Application # FH2203 - 0008

## Harnett County Department of Public Health Site Sketch

Property Location: 511412 Christmas Light RD

Date: 4-20-23

## Harnett County Department of Public Health Site Sketch

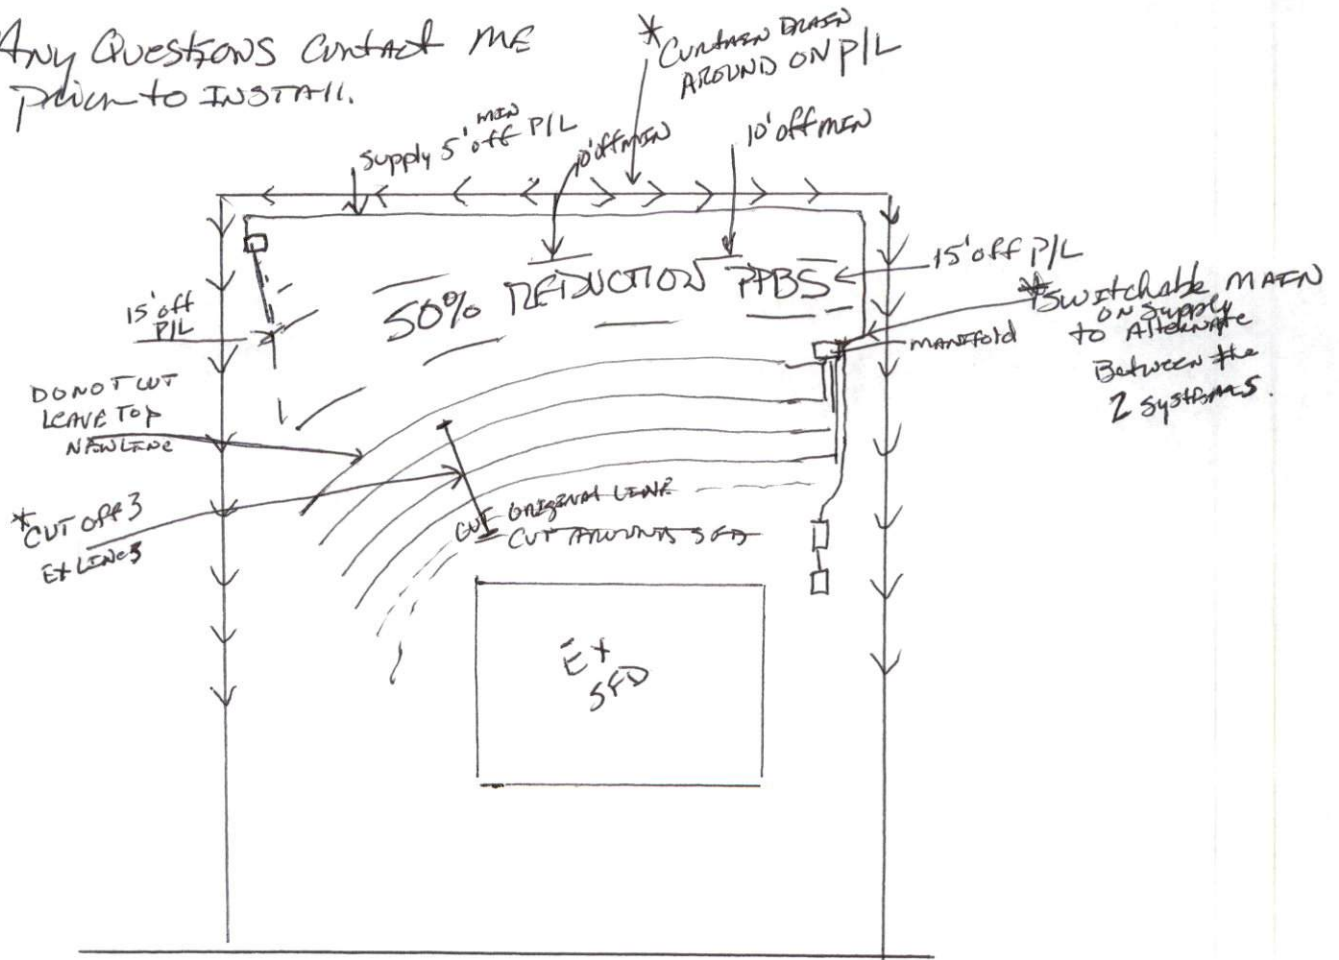
- \* Cut off EX LINES IN ZONE of wetness 3 Bottom LINES  
DO NOT CUT OFF TOP NEW LINE. MAY WANT TO DO LAST PART TO SEE IF CURTAIN DRAIN MAKES DIFFERENCE
- \* CURTAIN DRAIN TO BE INSTALLED AROUND SYSTEMS  
\* probably first thing that needs installing.
- \* Pump to Highest Side of property to start 50% Red Repair
- \* Any Questions contact me prior to install.
